25 November 2014

**State Significant Development Applications: Notice of Exhibition
Building R1 (SSD 6513), Building R7 (SSD 6623) and Building C2/C6 (SSD 6425)**

PLAN OF PROPOSED AUSGRID EASEMENTS OVER LOTS 3 AND 5 IN DP 876514

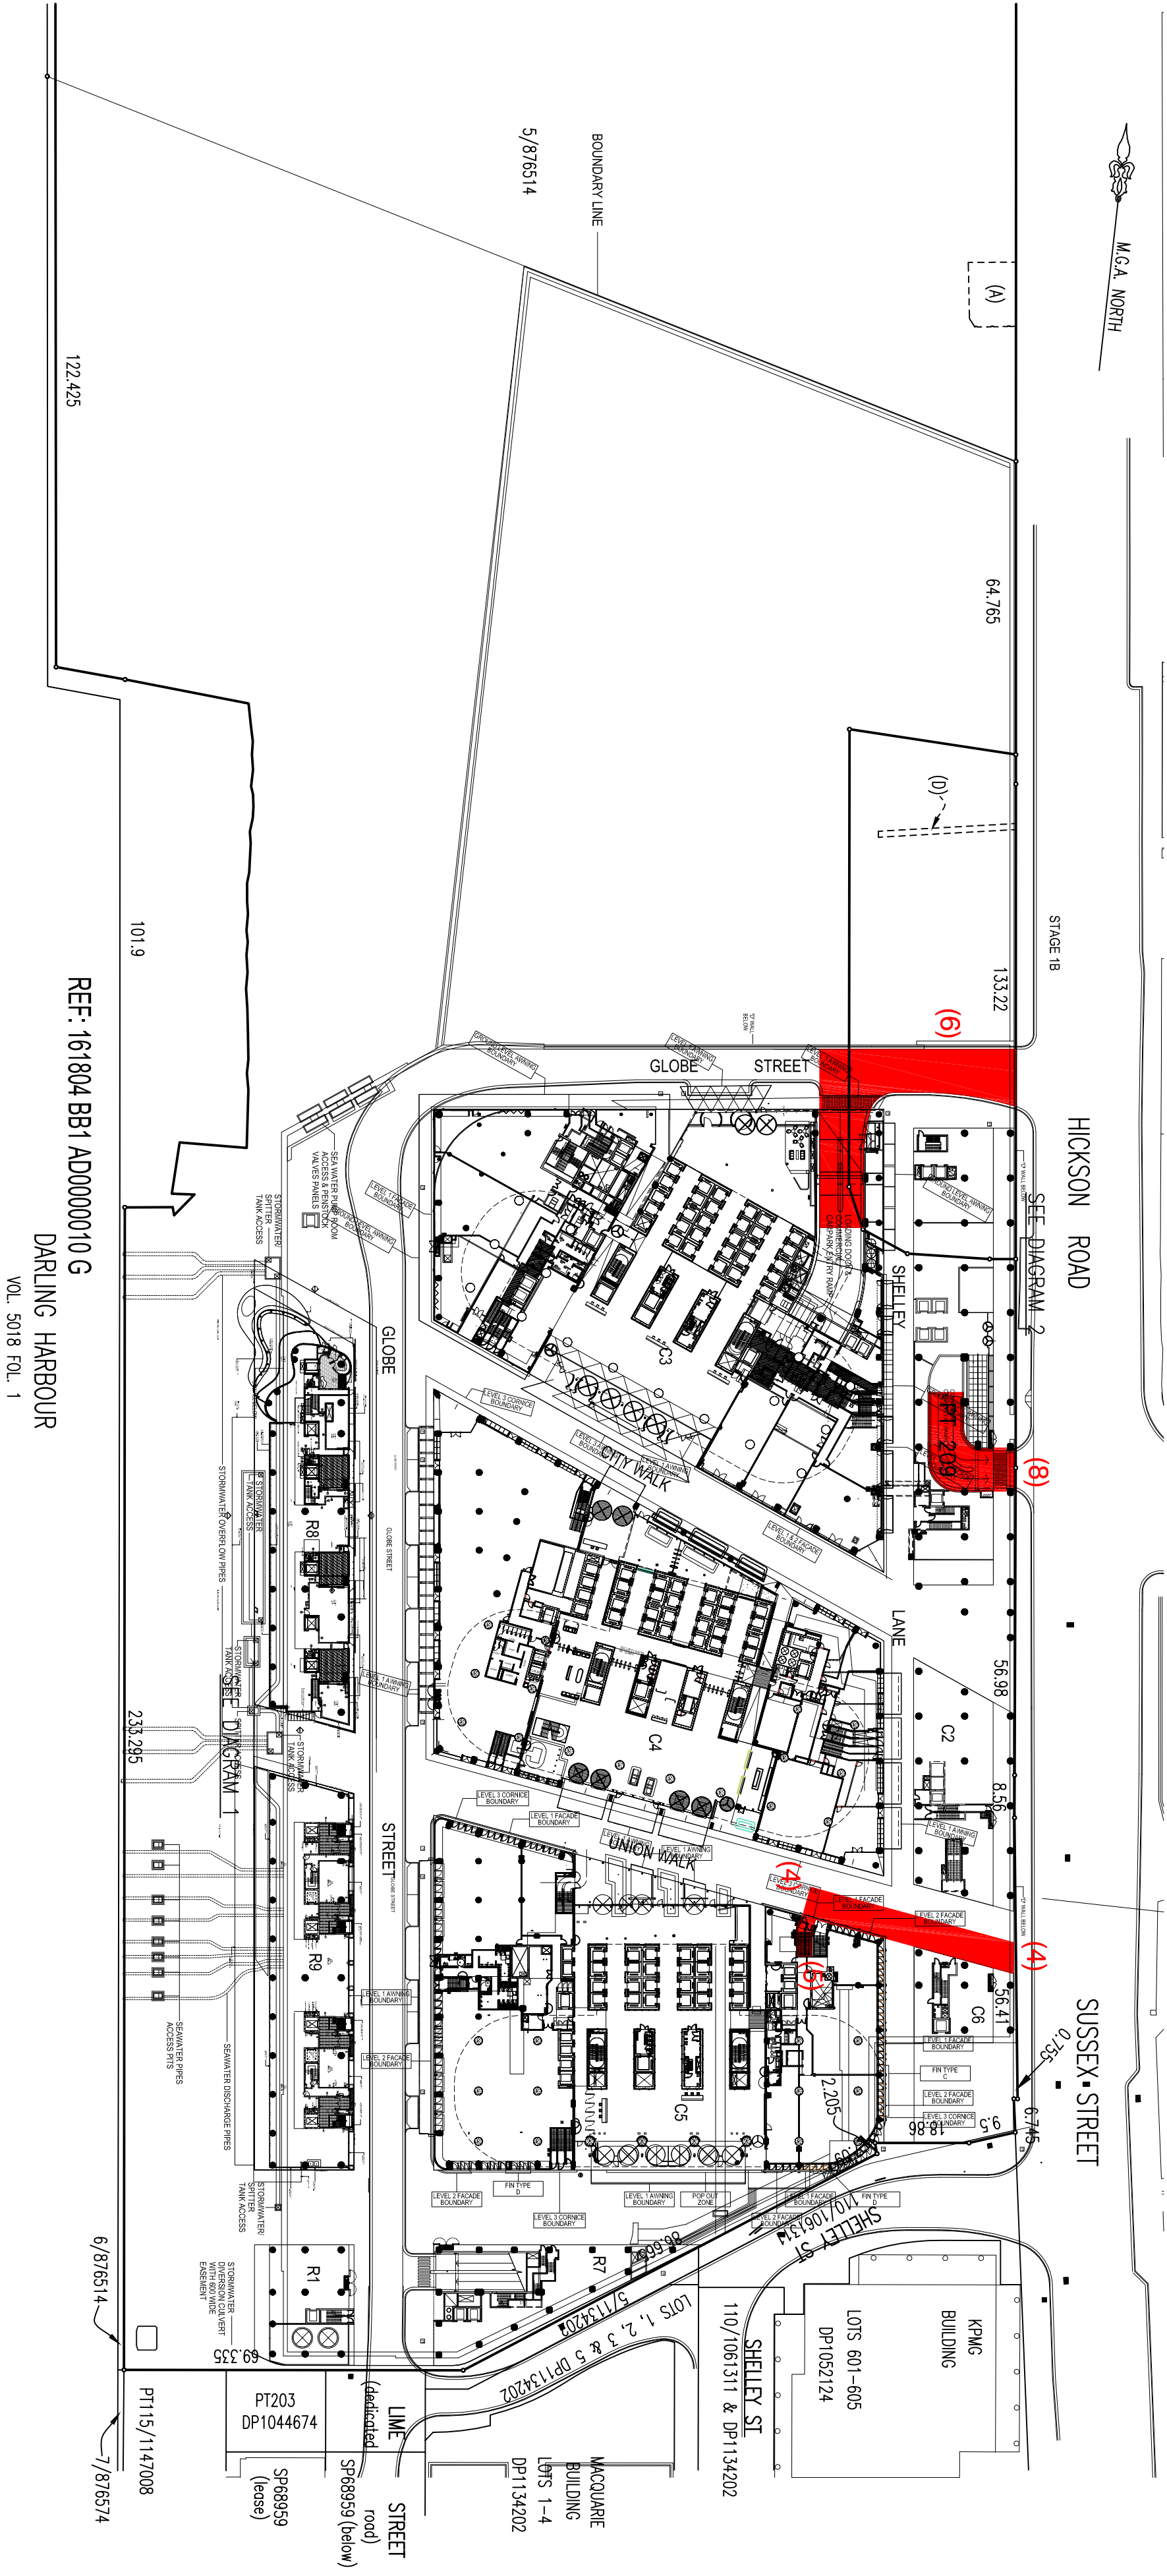
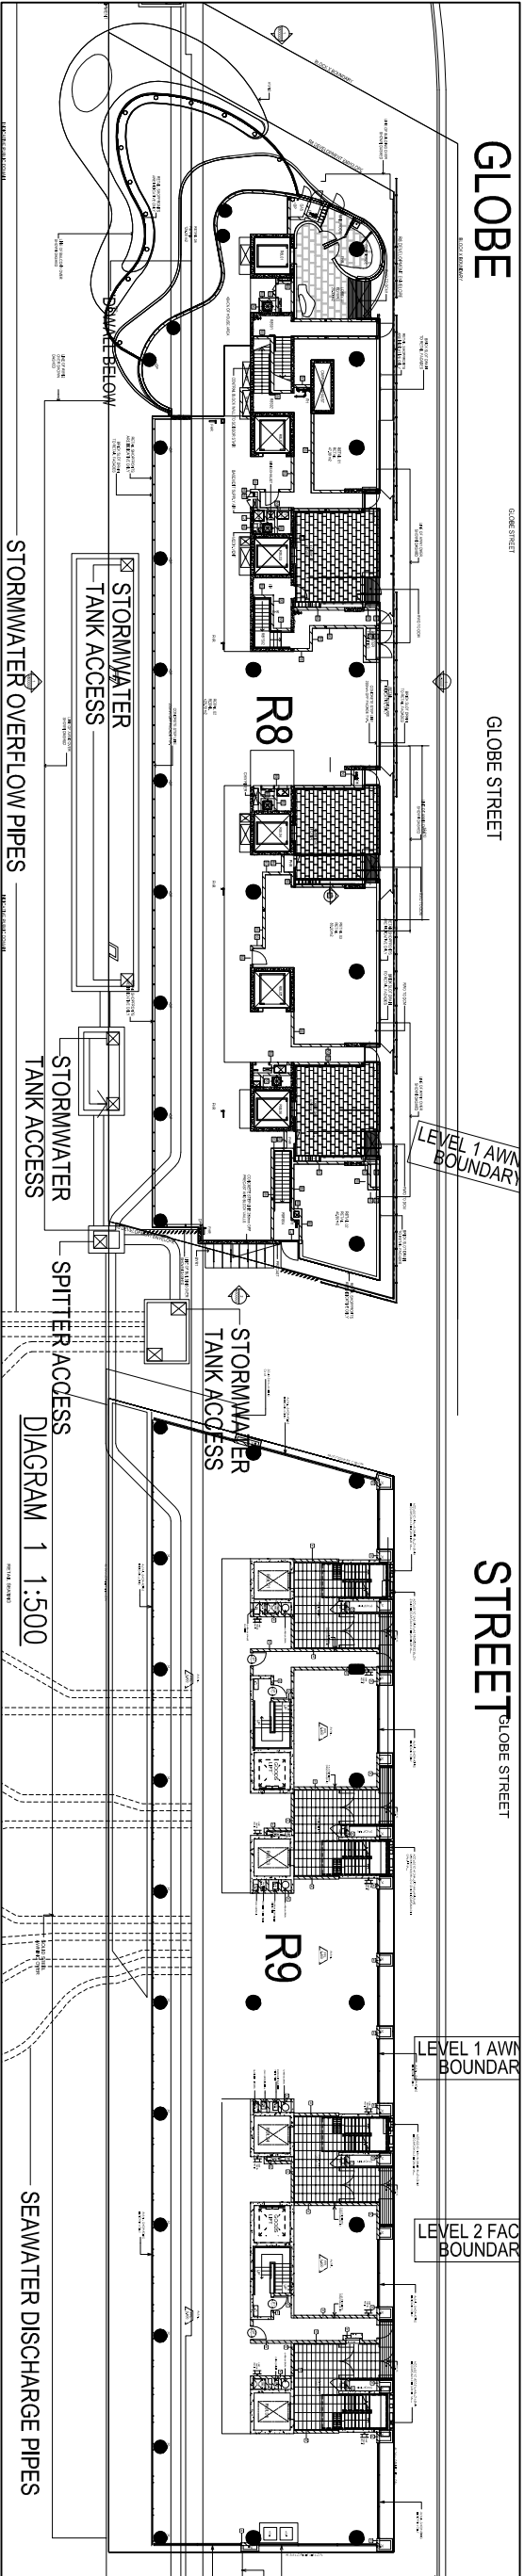
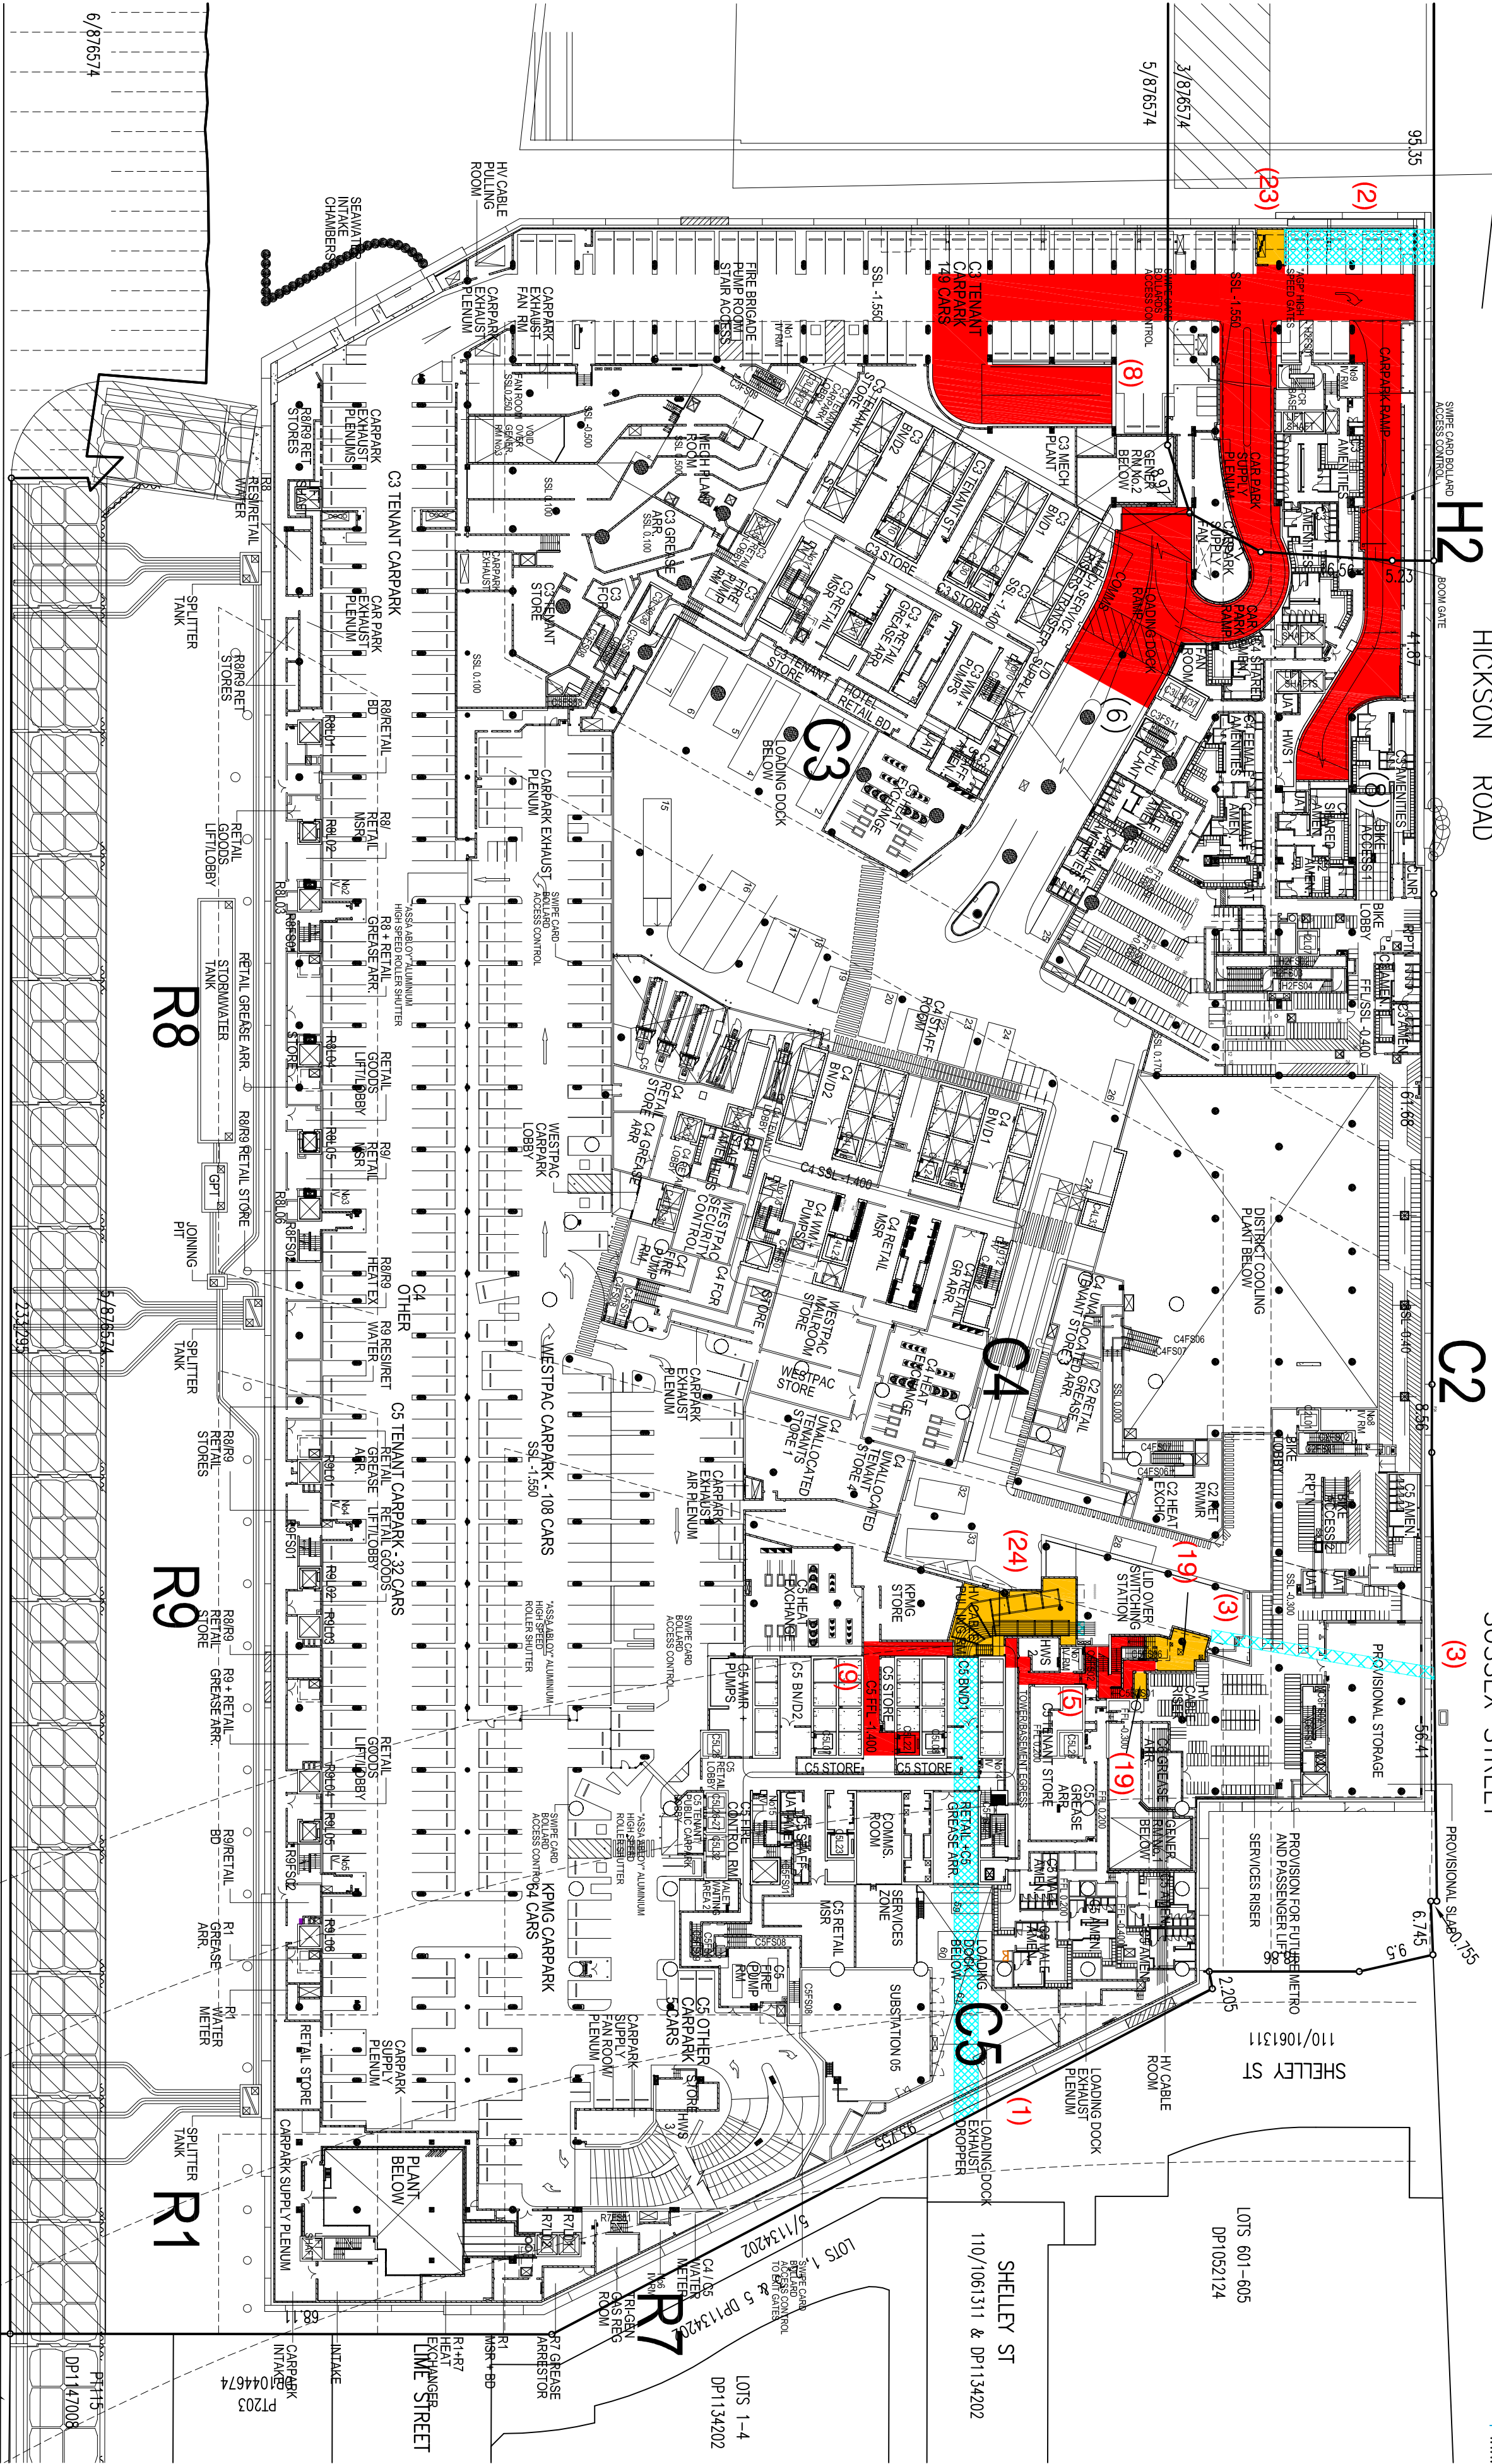
A high level review of the proposed plans for each of the developments has been undertaken and identified that the SSDs are in the vicinity of Ausgrid's future electricity infrastructure within the Barangaroo South Precinct.

1. The Proponent shall continue to negotiate with Ausgrid and finalise the following in favour of Ausgrid:
 - i. easements;
 - ii. leases; and
 - iii. rights of way,as contemplated in the enclosed plans prepared by Patrick Walsh of GeoStrata, dated 31 July 2014.
2. The Proponent shall provide reasonable access to Ausgrid for the installation and commissioning of Ausgrid's electrical infrastructure throughout the course of the project.
3. The Proponent shall not interfere with Ausgrid's electrical infrastructure.
